## Department of Planning and Environment

Our ref: Pymble Ladies College - Grey House Precinct - SSD-17424905

Subject: **Request for additional information- Pymble Ladies College - Grey House Precinct (SSD-17424905)**

## ELC UNENCUMBERED AREA

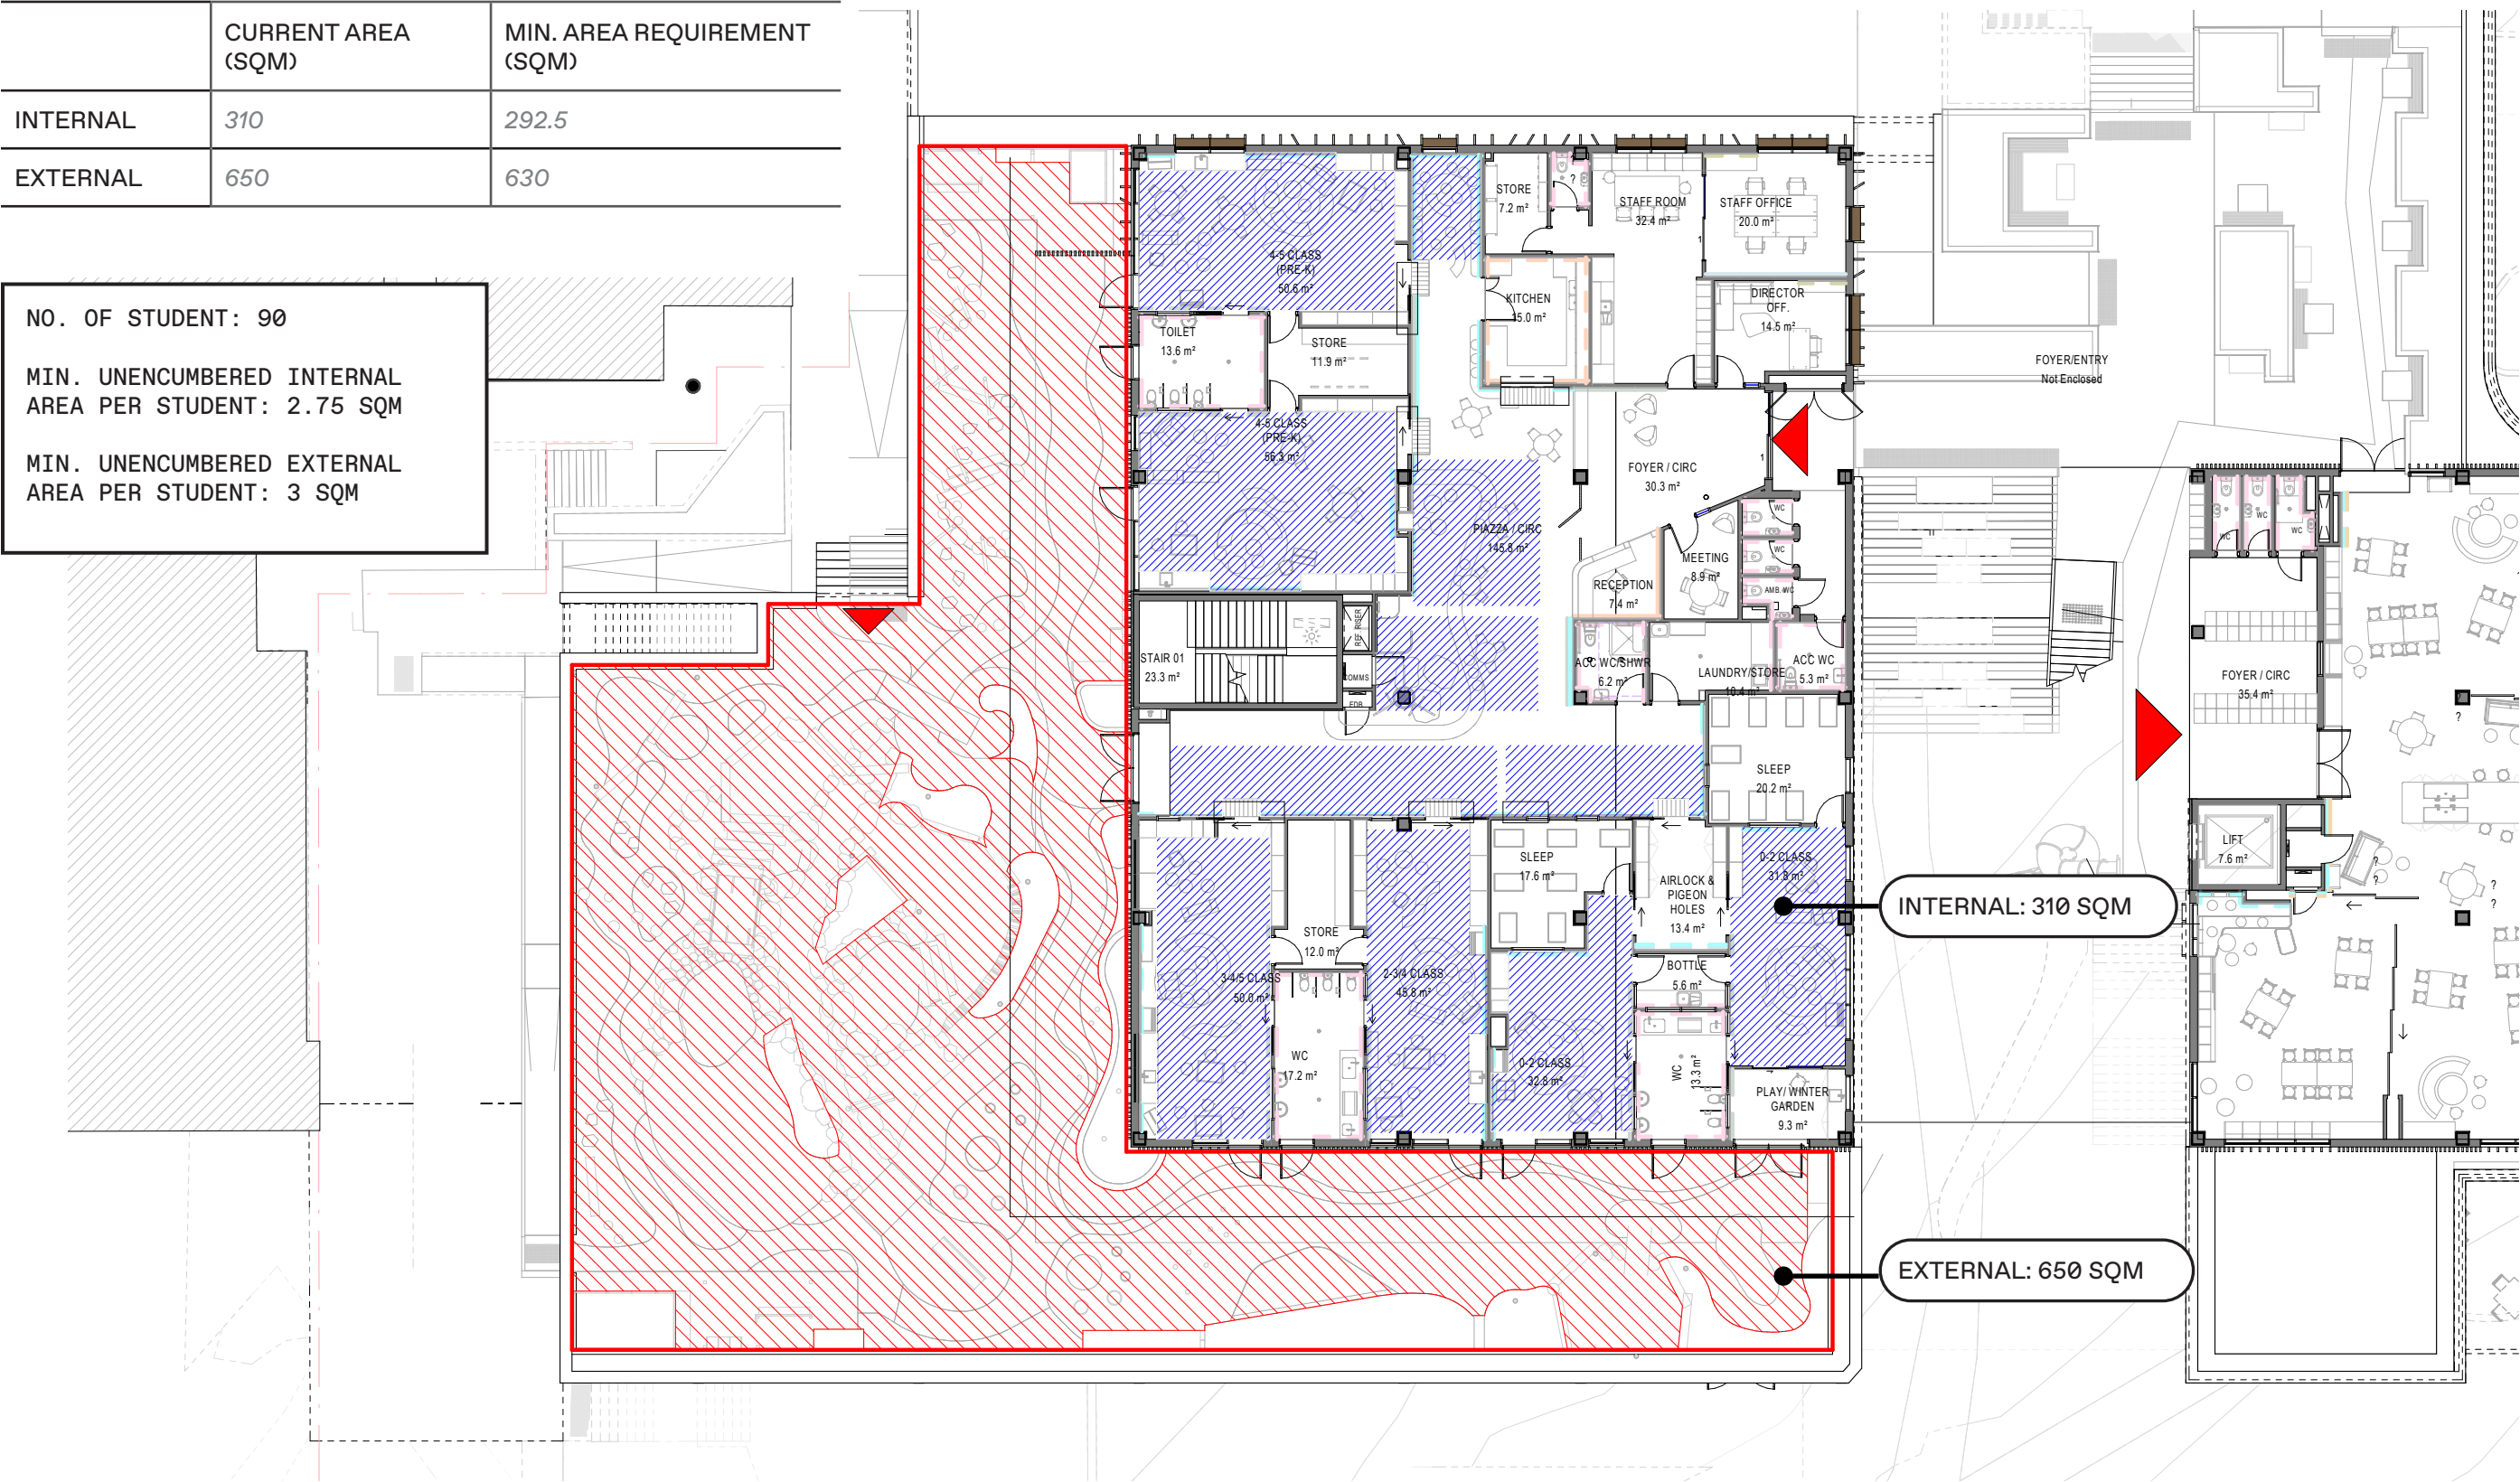
2. The open space area allocation for early learning centre (ELC) students is not clear. The child care assessment table submitted with the EIS does not include any numerical data regarding the unencumbered outdoor and indoor play areas to demonstrate their compliance with the relevant standards (the childcare assessment table include incomplete highlighted information rather than a number). The Department has previously requested this; however the information has not been submitted.

The Department requires you to clearly demonstrate on the architectural plans and in a table., the delineation of the unencumbered outdoor and indoor play area for the proposed ELC, to comply with the requirements of the Education SEPP.

## Area Schedule

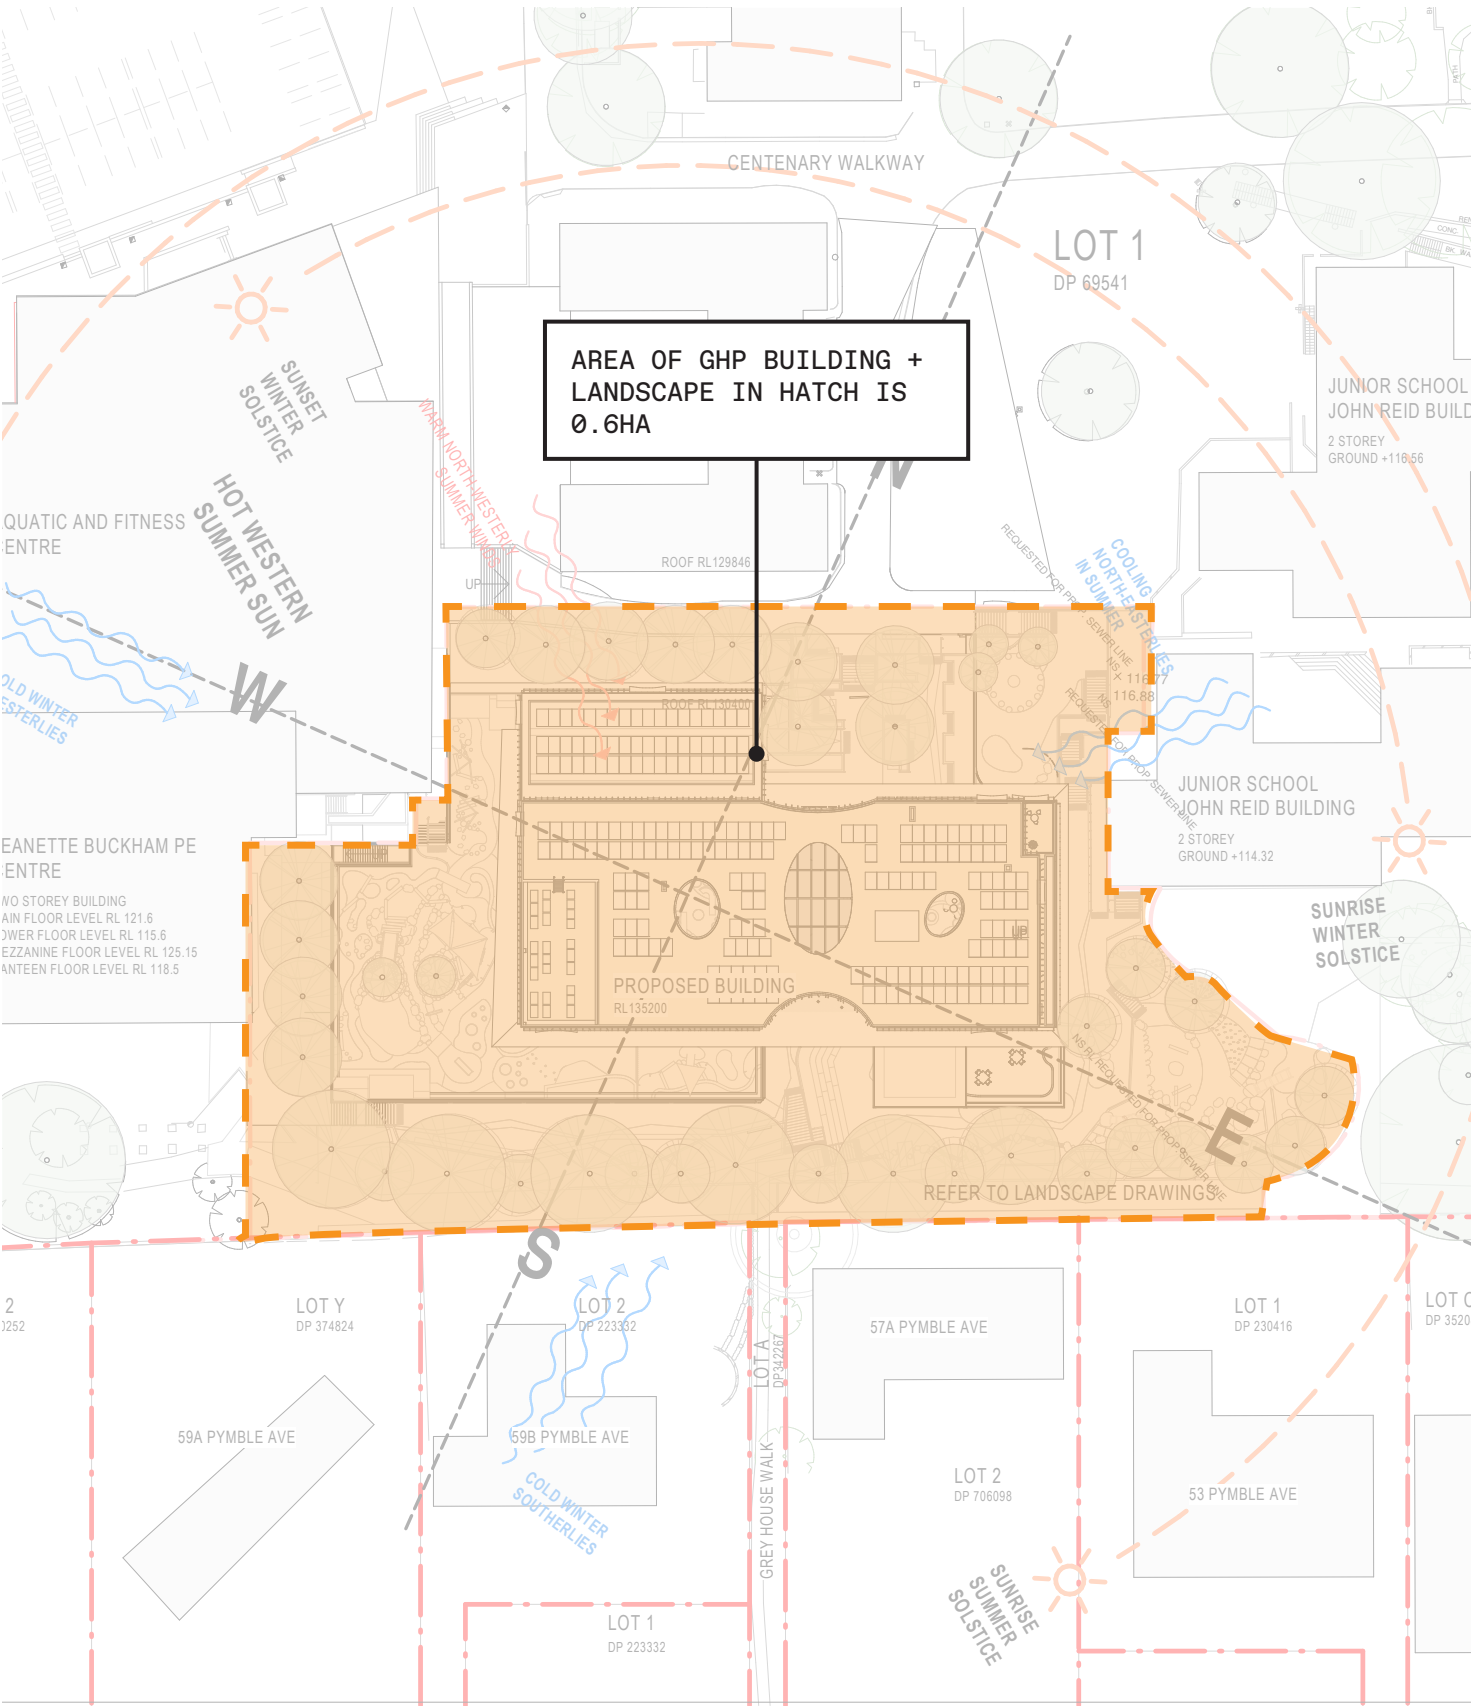
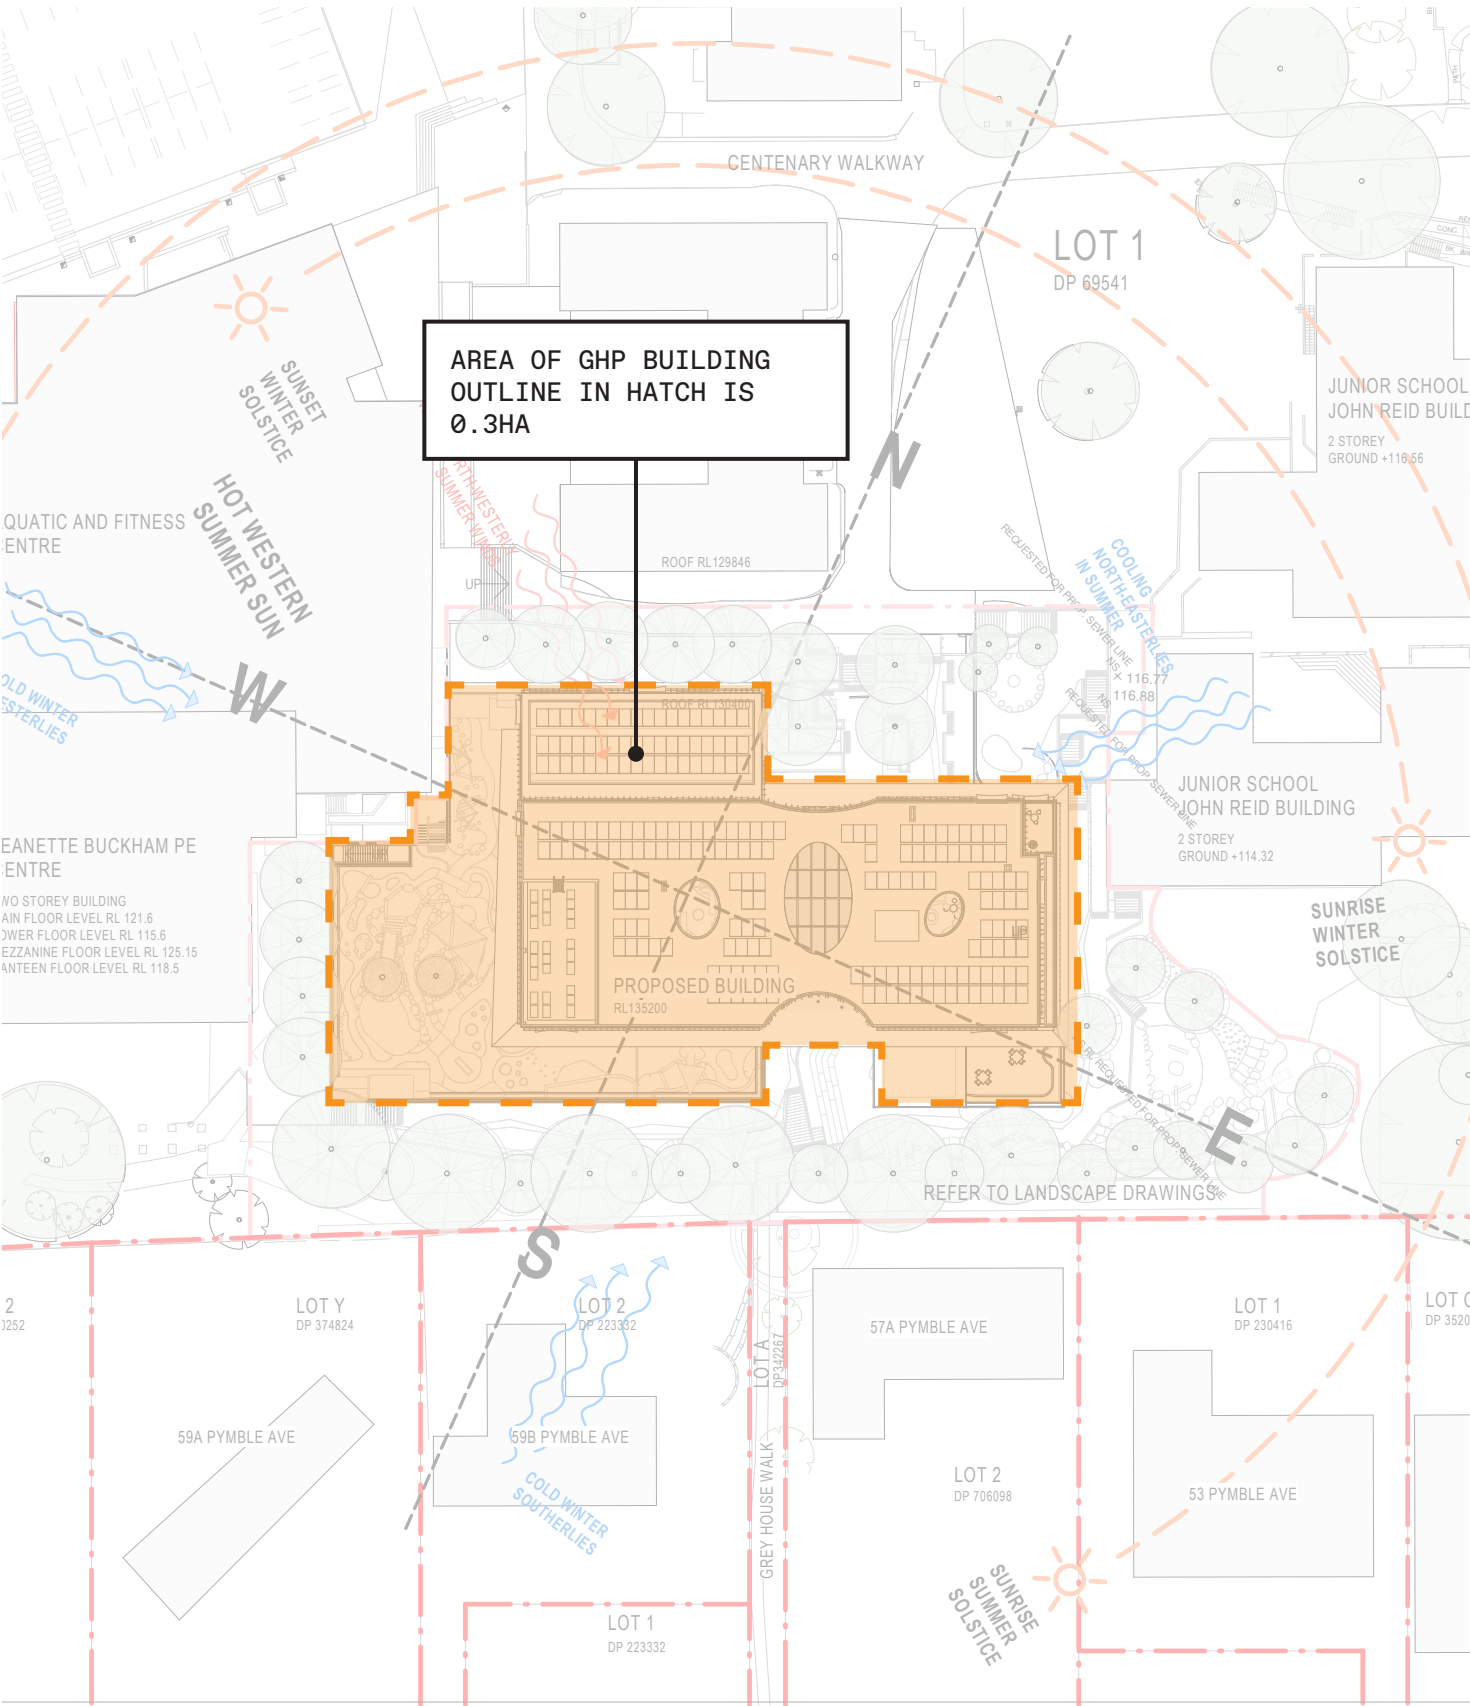
3. The architectural drawings and supporting documents in the RtS, demonstrate that the northern portion of the building footprint has been reduced. This implies a change in the overall gross floor area (GFA) of the development. Please provide an amended schedule of the GFA to indicate the extent of its reduction.

## Site Area

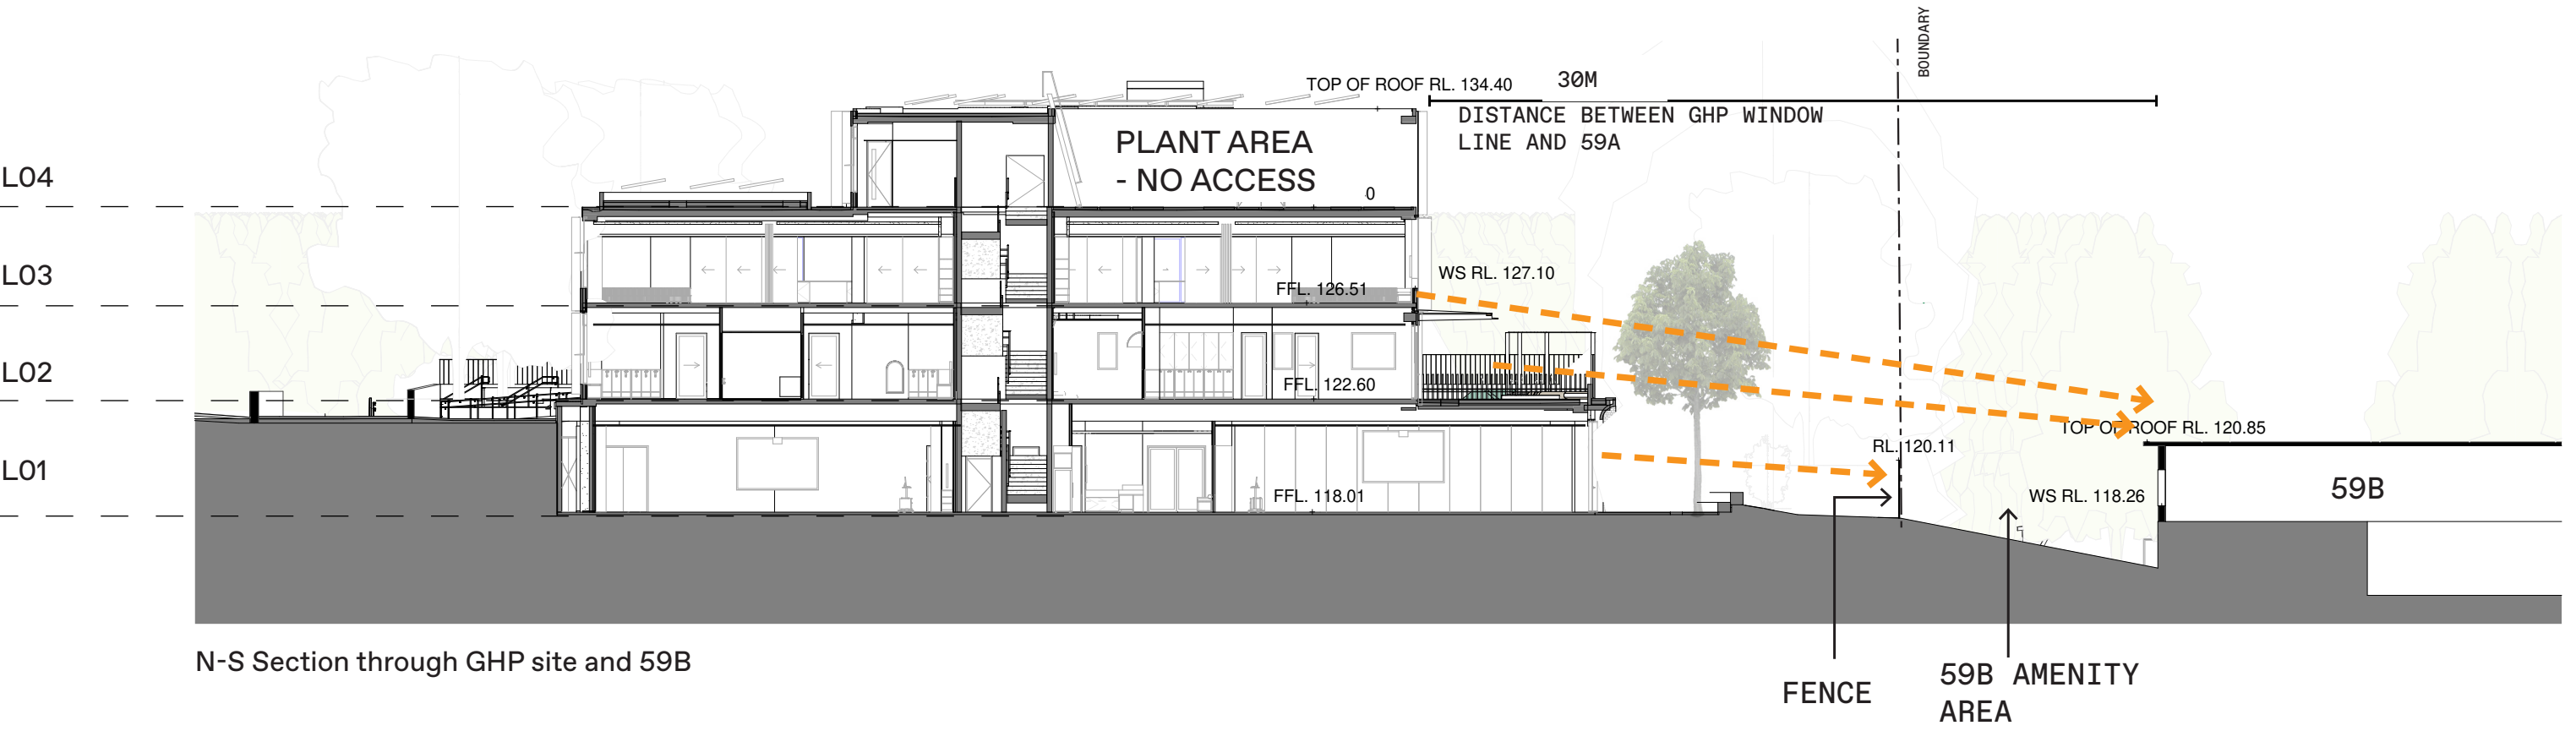
4. Please confirm whether the site area for the Grey House Precinct is 0.3ha or 0.06ha.
5. The Department notes the justification provided with regard to overlooking and visual privacy. However, the Department is concerned that the level 3 classroom windows and level 2 balcony of the proposed building may directly overlook on to the swimming pool and courtyards of the residential properties to the south (facing Pymble Avenue).
